**Applicant:** Heyford Park Estates Limited

**Proposal:** Discharge of condition 2 (landscaping scheme) 4 (landscape management plan) 6 (tree pits) of 17/00610/REM

- 2.1. This application seeks to discharge: Condition no.2 (Landscaping Scheme); Condition no.4 (Landscape Management Plan); and, Condition no.6 (Tree Pits) of planning reference 17/00610/REM.

Title: Planting Proposal  
Camp Road Sheet 1 of 2  
Project: Heyford Park, Camp Road & Trident  
Client: Dorchester Living  
Date: July 2018  
Scale: 1:200 @ A1  
Drawing No: 1619 A12 01 C  
Rev:

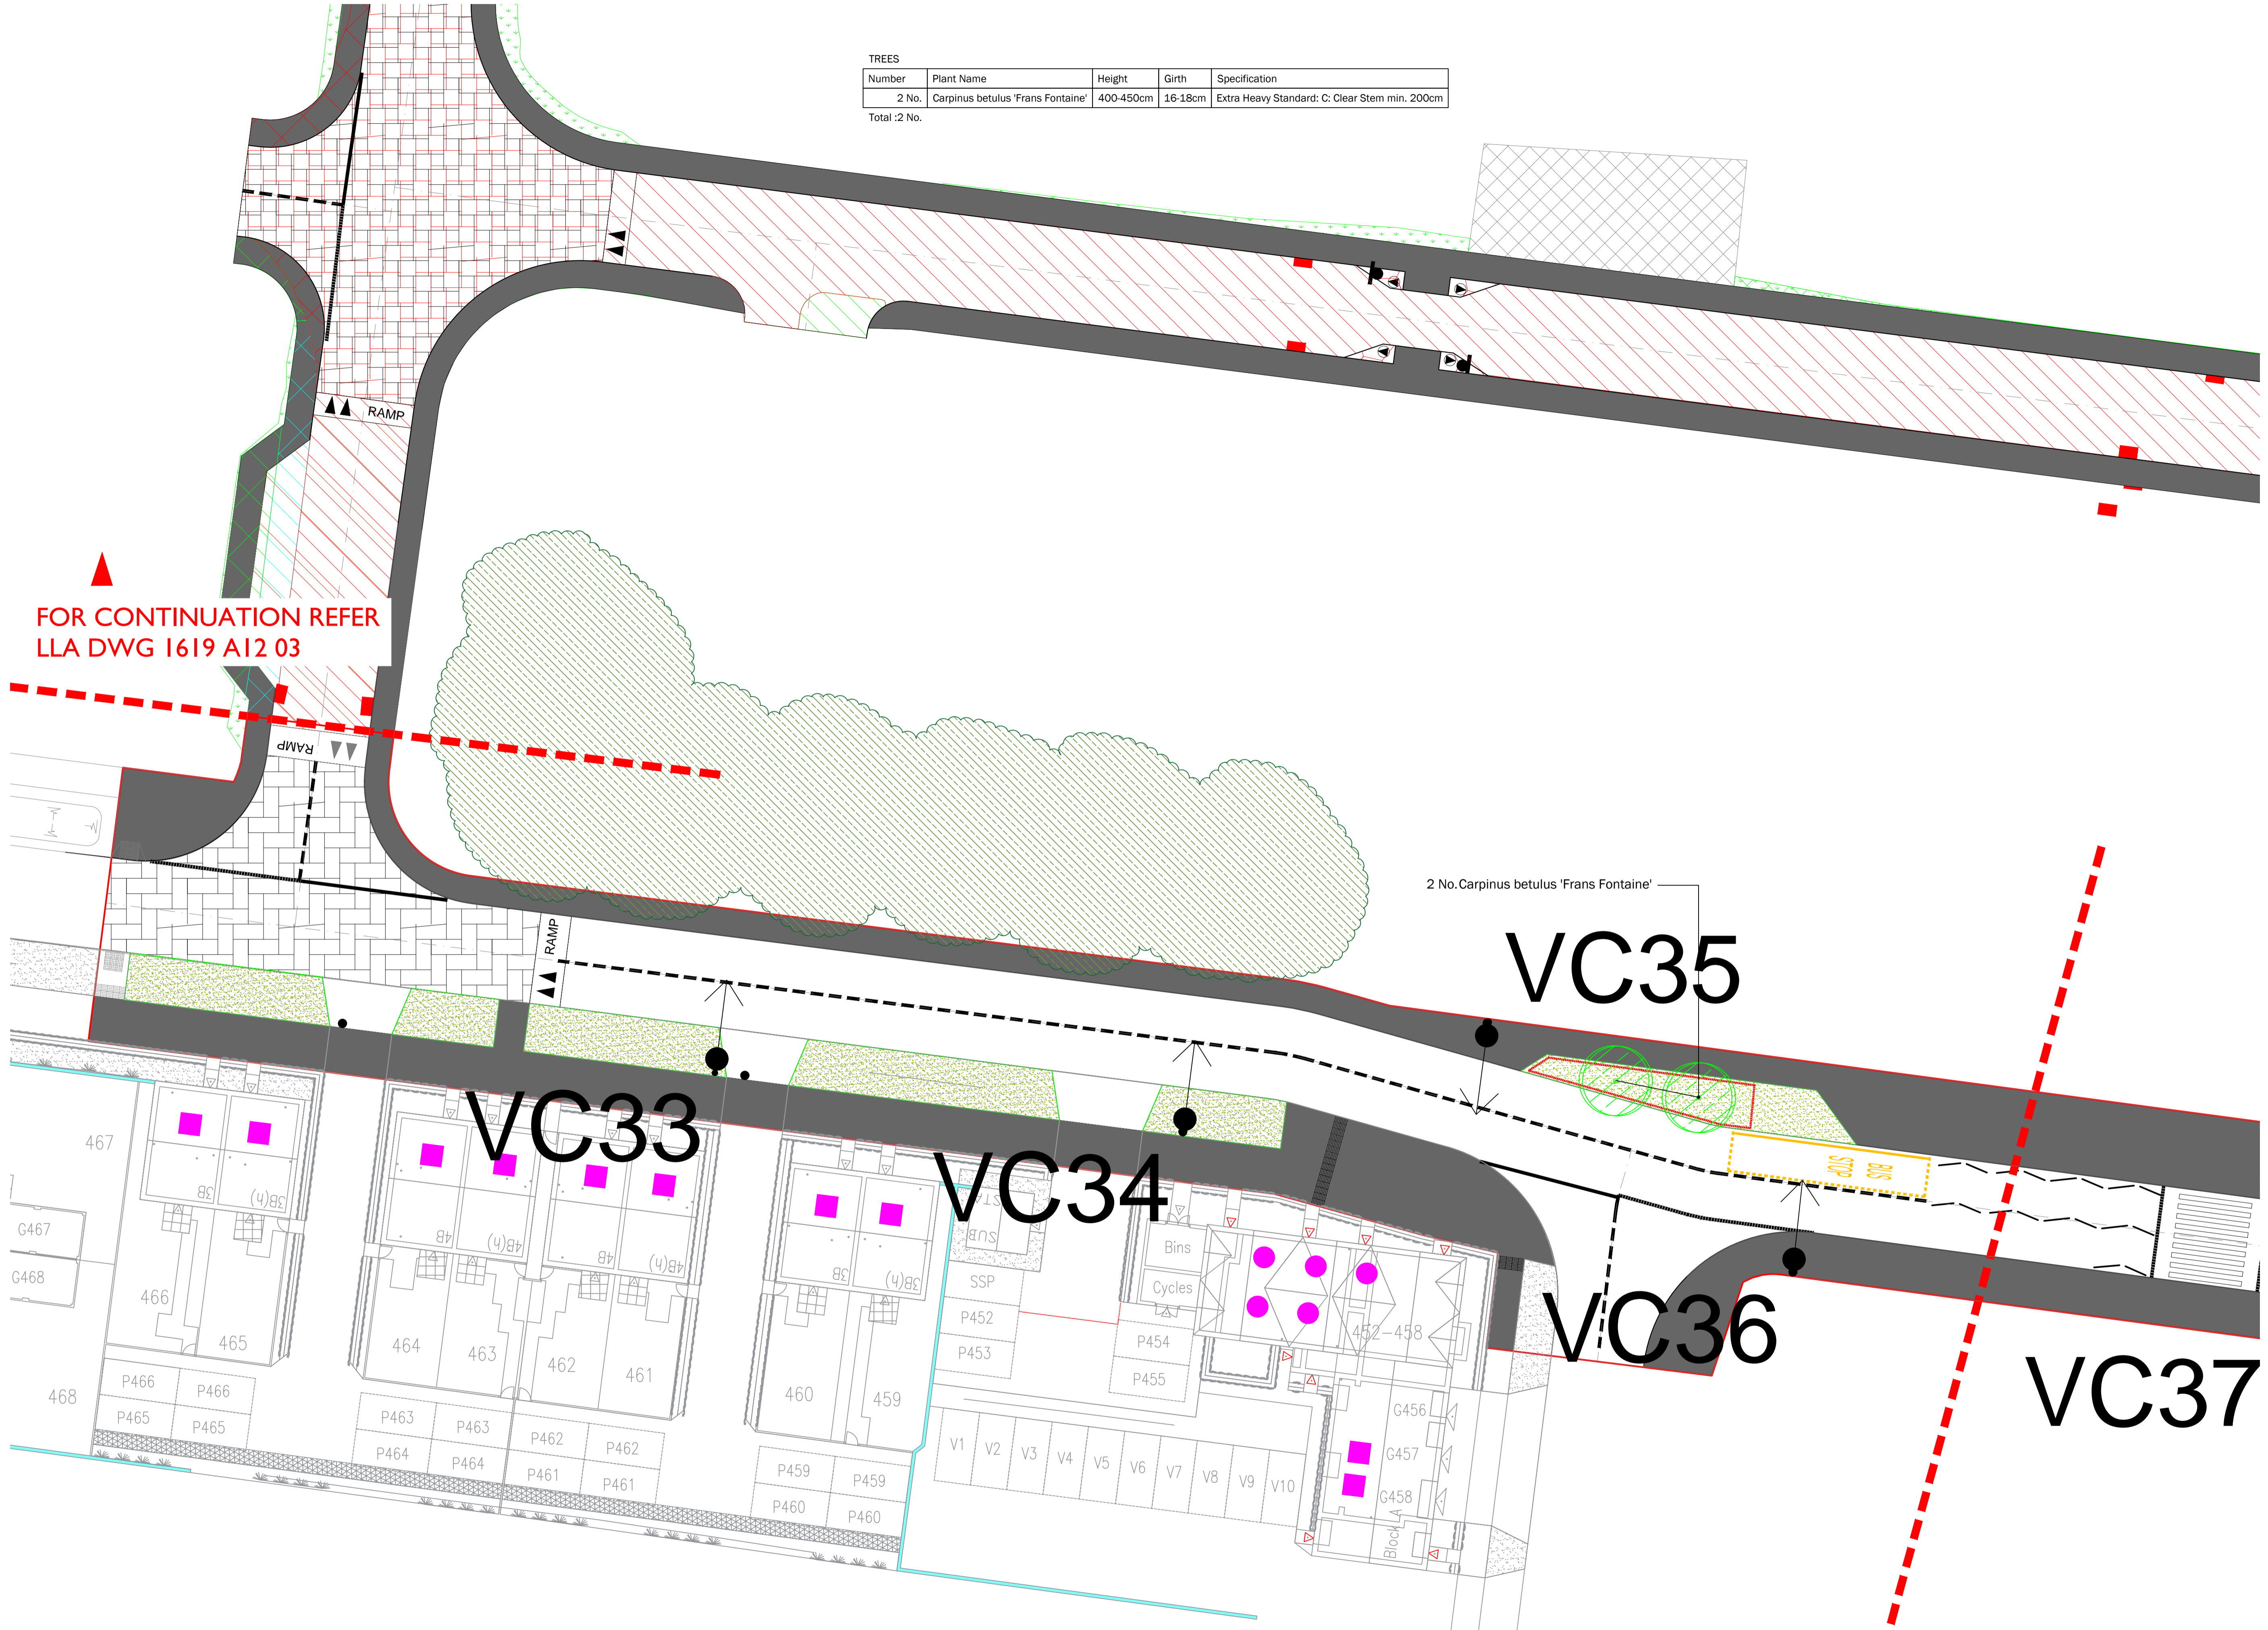
*'regarding the use of Pedula Pubescens on Camp Road immediately adjacent to the bus stop. My main concerns being, Betulas often do not compartmentalise wounds well, therefore may have a decreased longevity as the proposed location will likely mean regular pruning will be required so to prevent interference with the bus stop. Furthermore I have concerns 3 trees within this small grass area may be too dense, potentially causing competition for nutrients/moisture within the soil reducing vitality.*

*Has there been a prior agreement to use Betula Pubescens? If not could I suggest an alternative street tree of a hardy nature, with ideally a thin streetwise canopy that should prevent the need for regular pruning in the future?*

- 5.1 Having regard to Condition no.2 the scheme for landscaping specifies details of the proposed tree and shrub planting including their species, number, sizes and positions, together with grass seeded/turfed areas; and, details of the hard surface areas. Significantly, the proposals have been amended in response to the CDC Arboriculture comments – providing a tree of a more 'hardy nature' to minimise future maintenance.

Title:	Landscape Specification & Details
Project:	Heyford Park, Camp Road & Trident
Client:	Dorchester Living
Date:	July 2018
Scale:	NTS @ A1
Drawing No:	1619 A12 10 B
Rev:

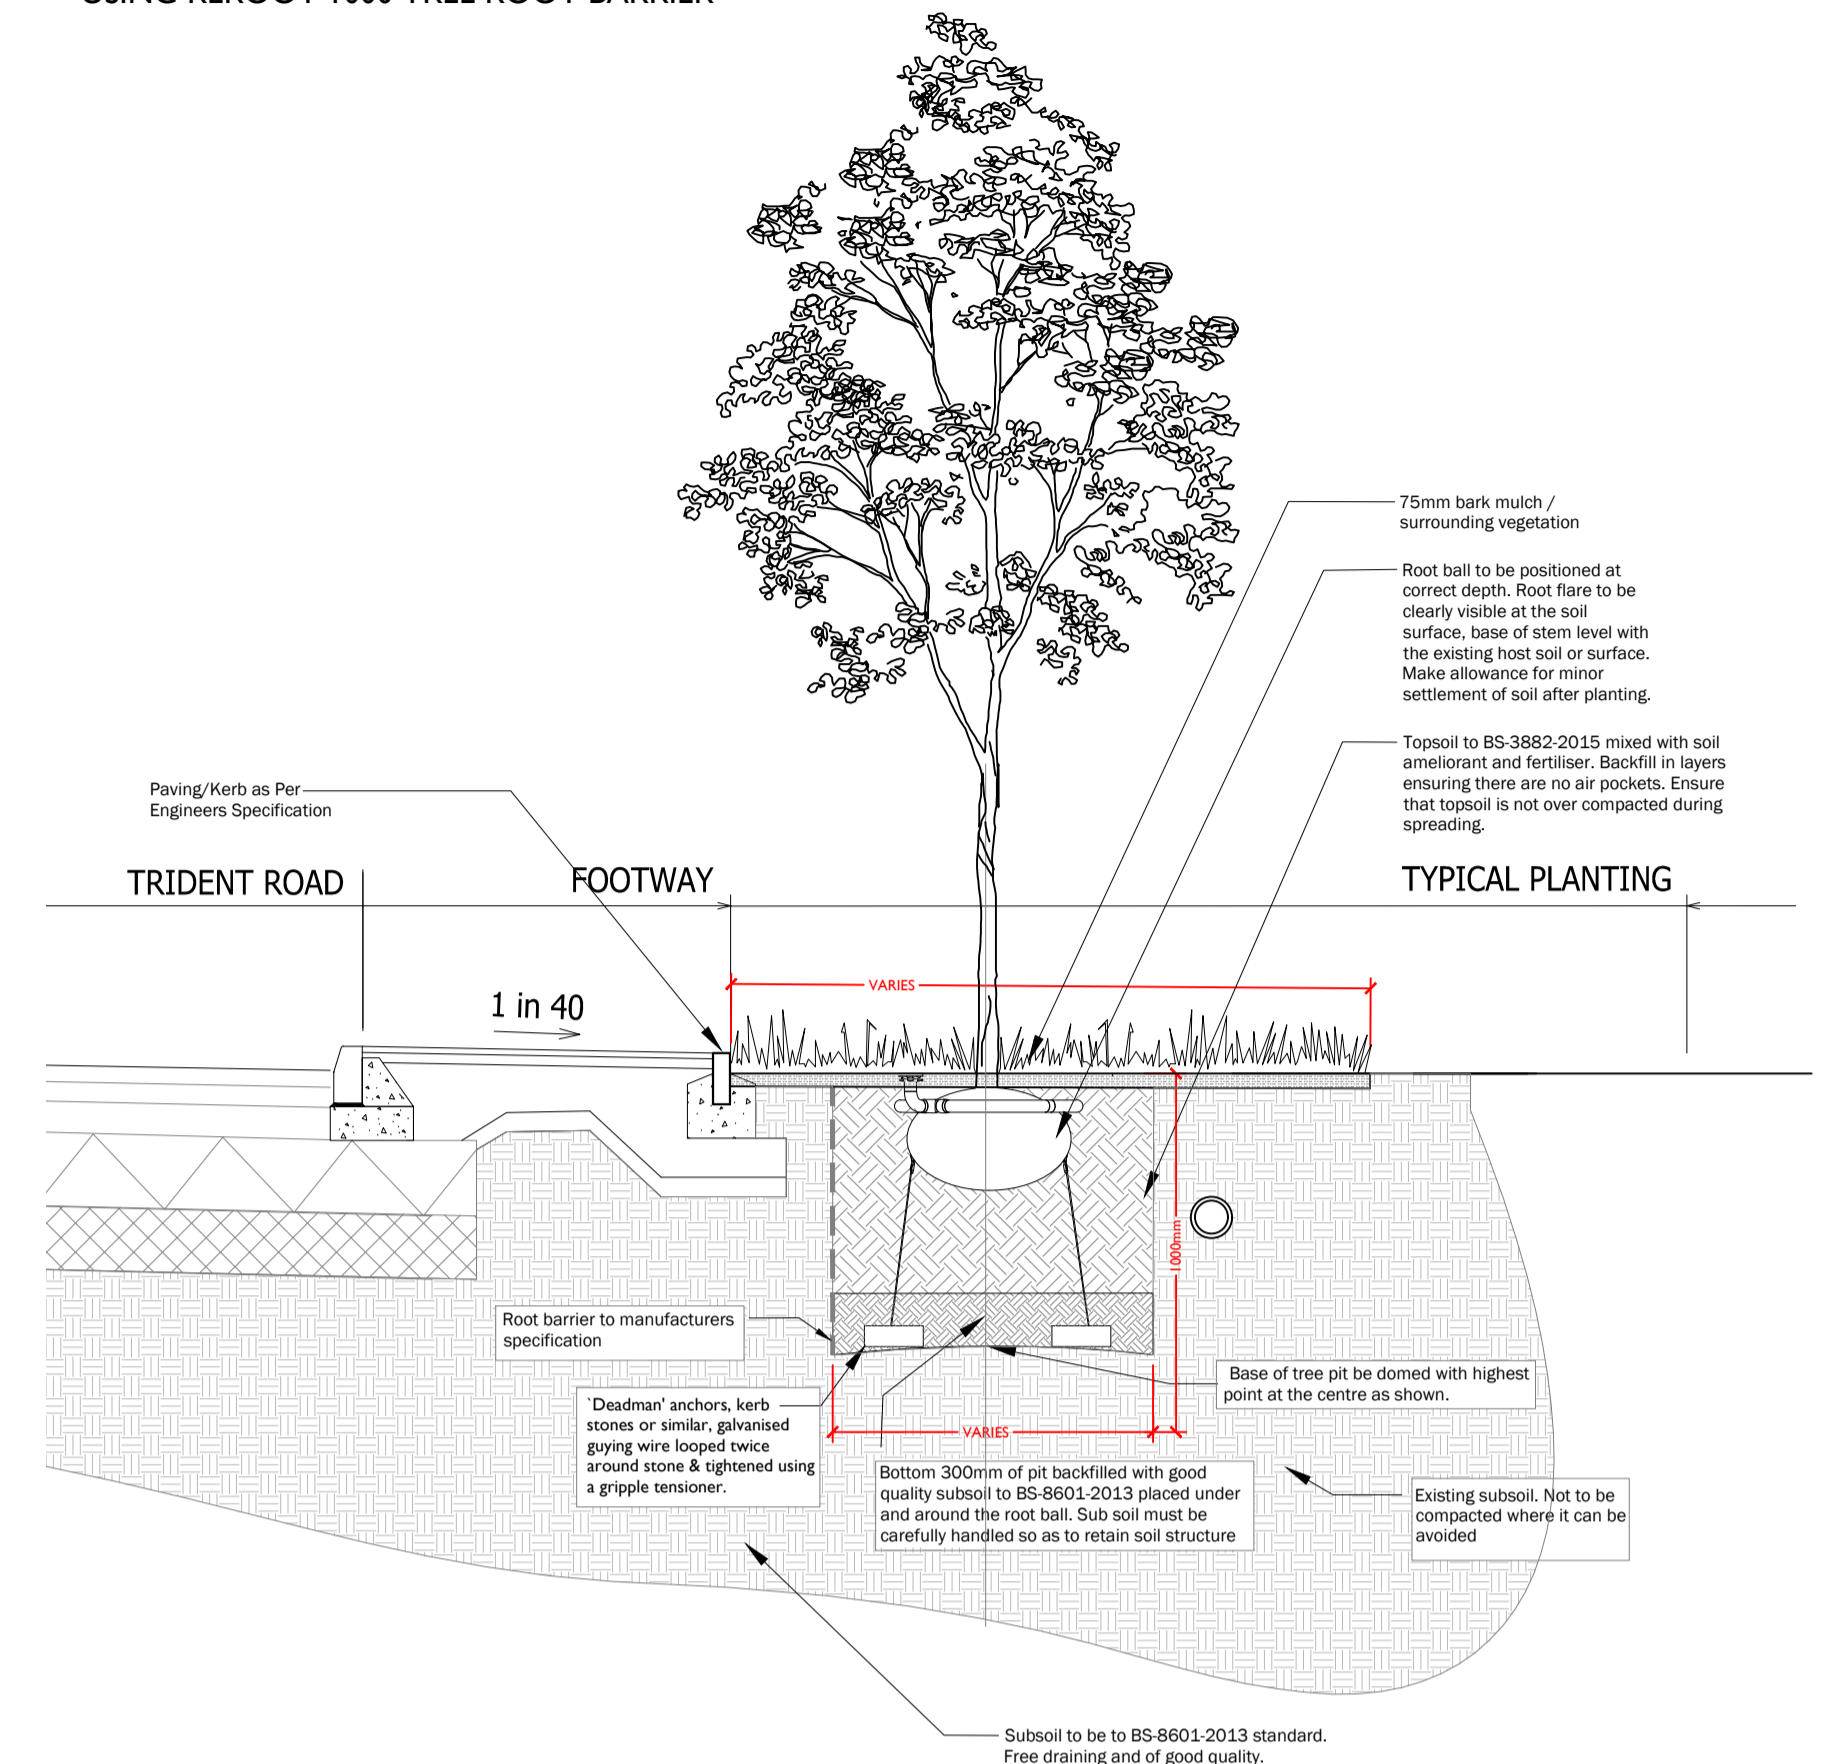
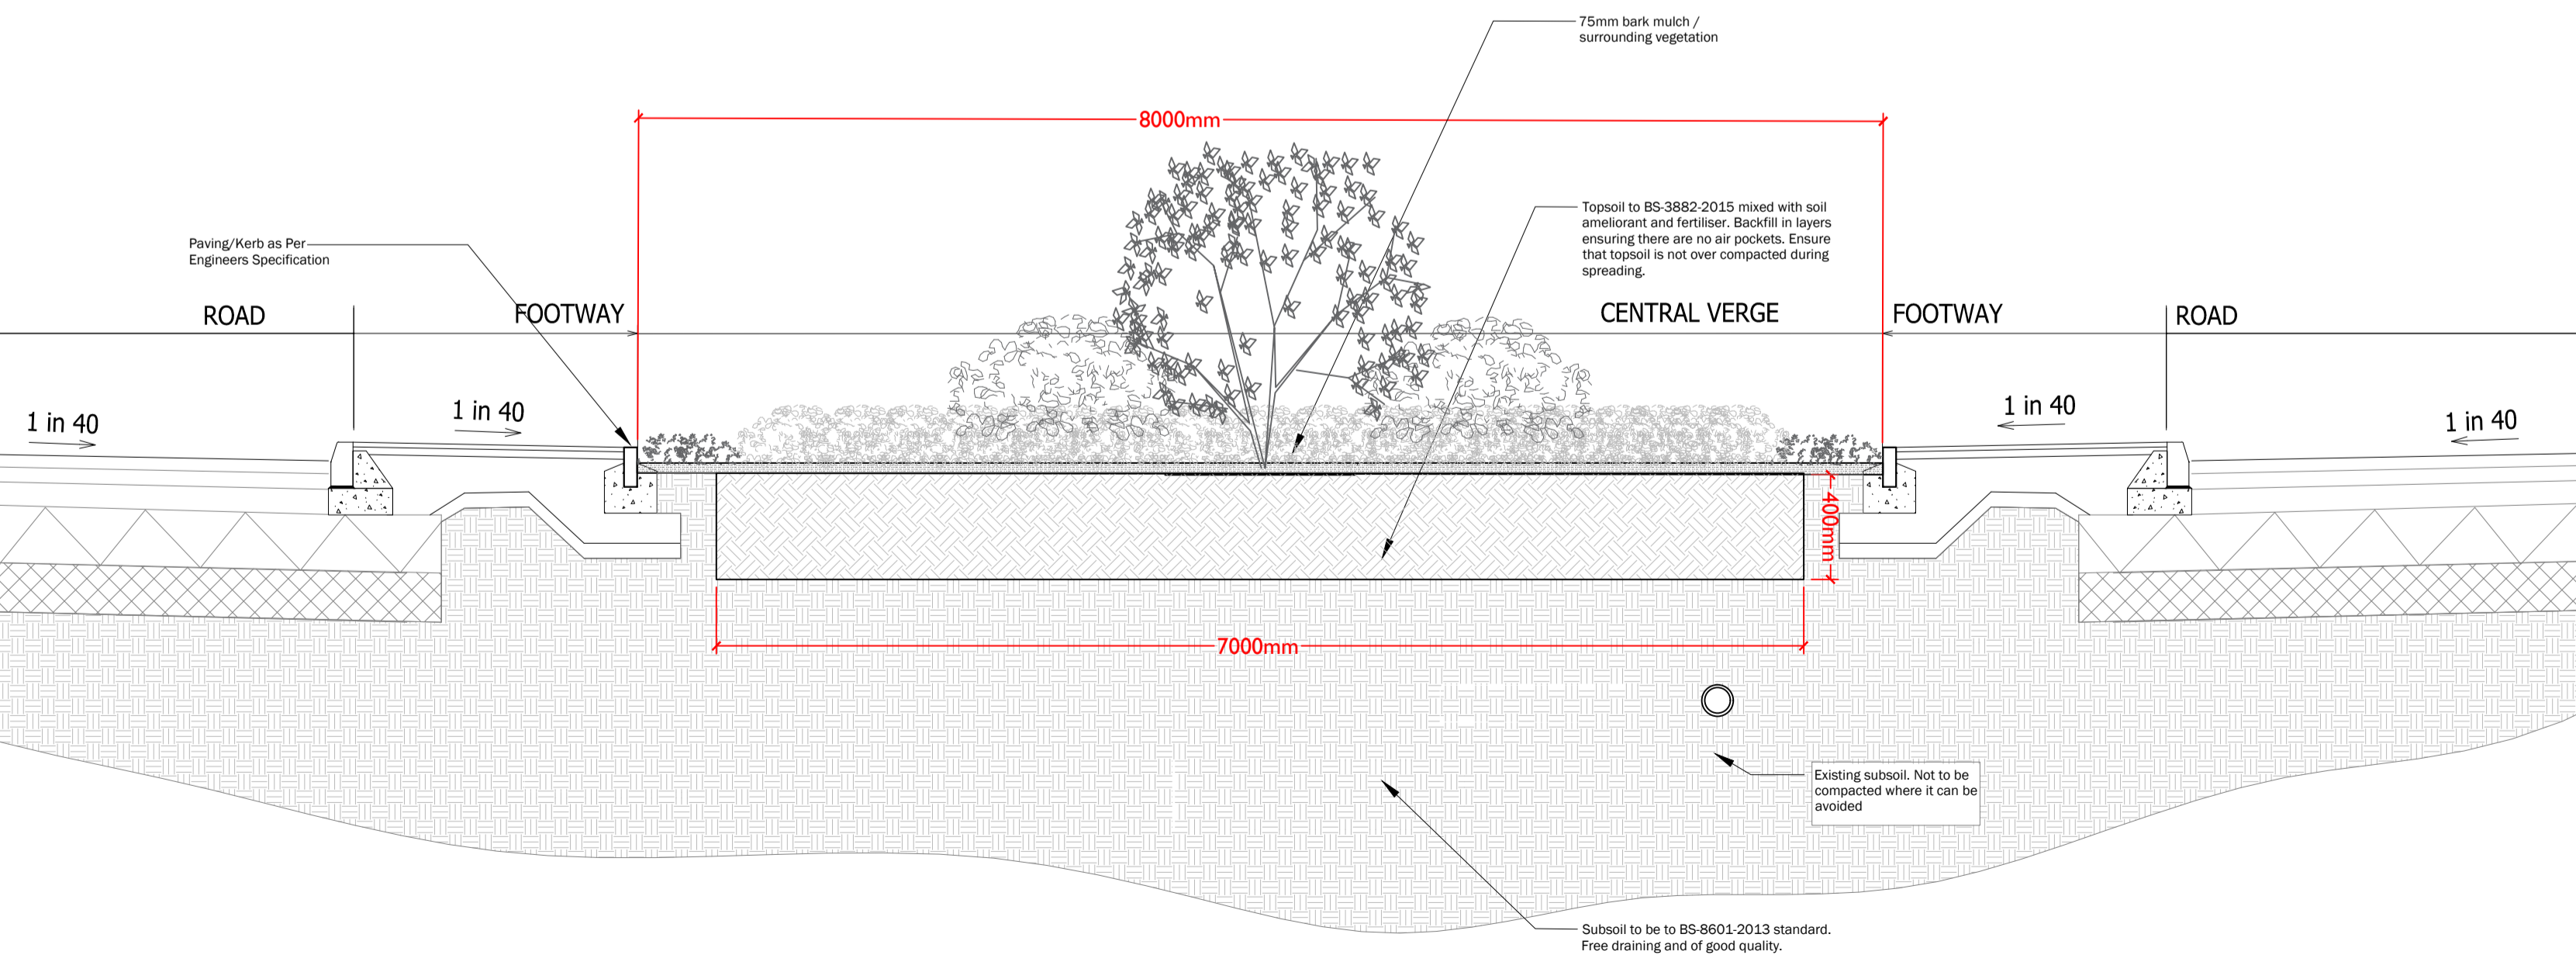
*Regarding the tree pit detail, I am content with the information provided, and have no further comments to make.'*

- 5.3 Finally, the proposals in respect of Condition no.6 provide details, locations, specifications and construction methods for all purpose-built tree pits and associated above-ground features.
